Our Ref: FP/136/19/HH

**Town & Country Planning Act 1990 (as amended)
Town & Country Planning (Development Management Procedure) (England) Order 2015
Application for Planning Permission for Works or Extension to a Dwelling**

Development Small single storey side extension

Location 19 Sea Drive Felpham

Site Block Plan 1:500

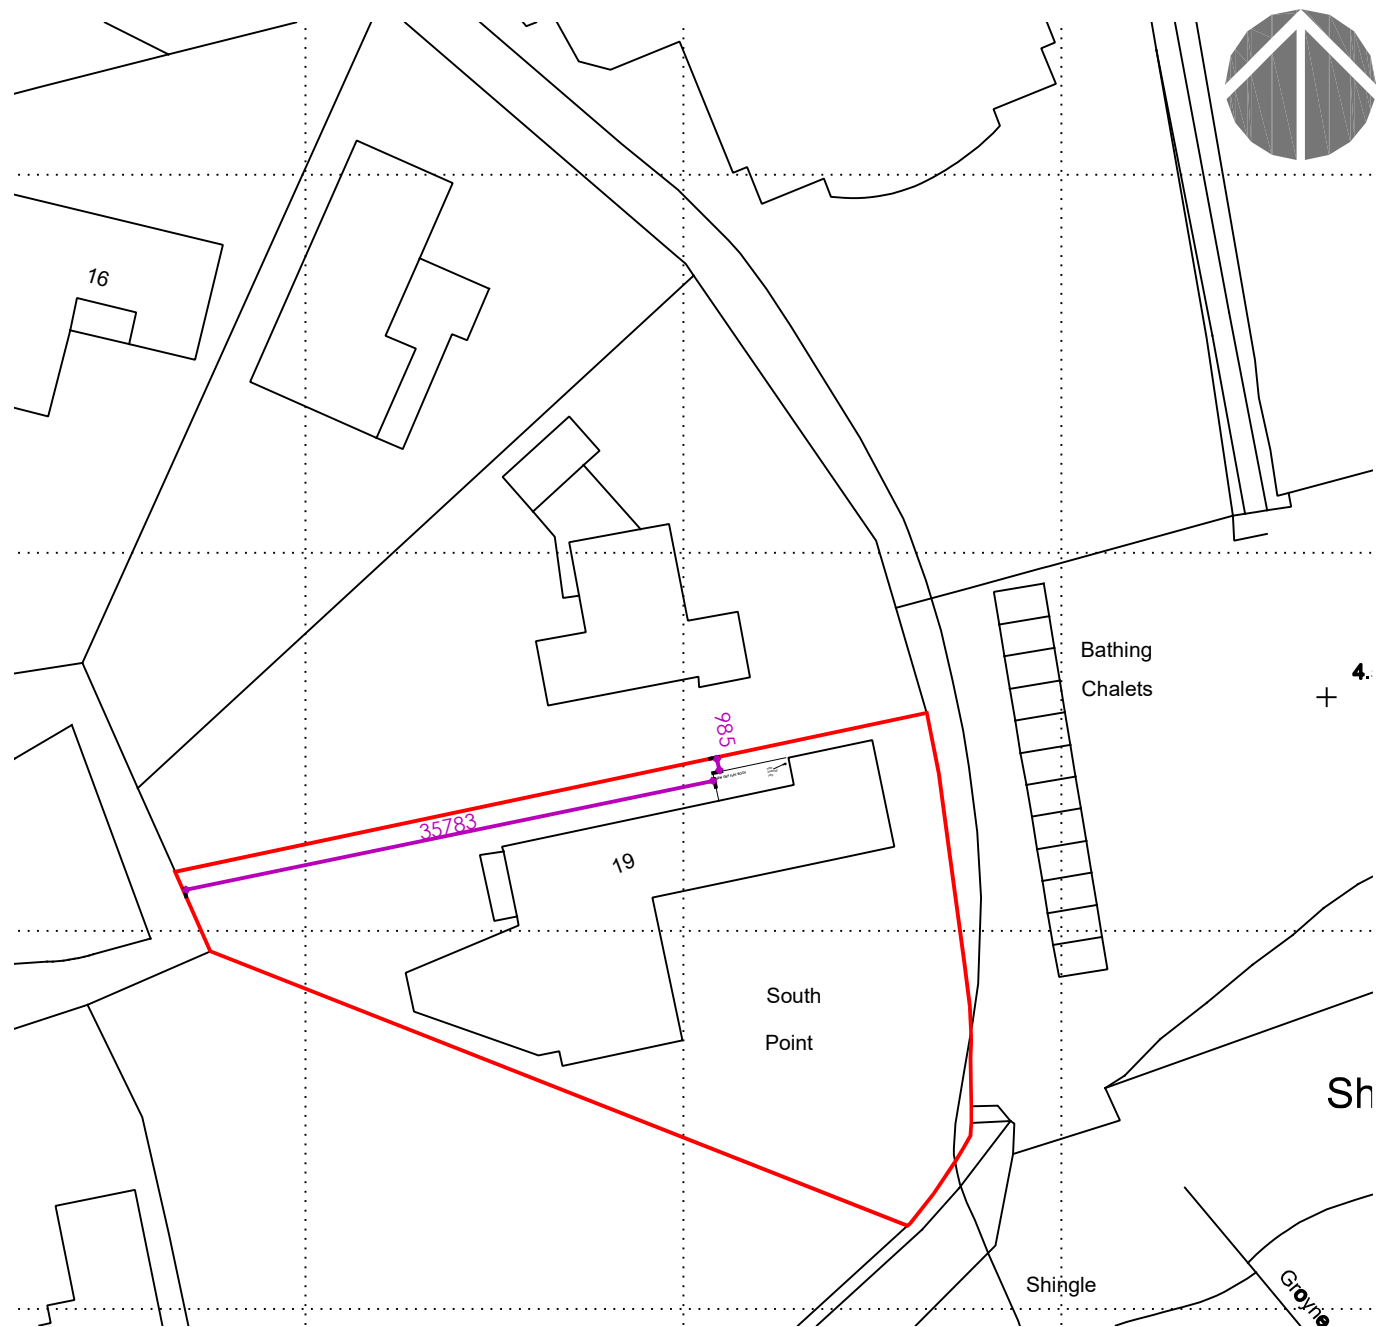
Block Plan

Please provide dimensions on your block plan from the side extension to all site boundaries.
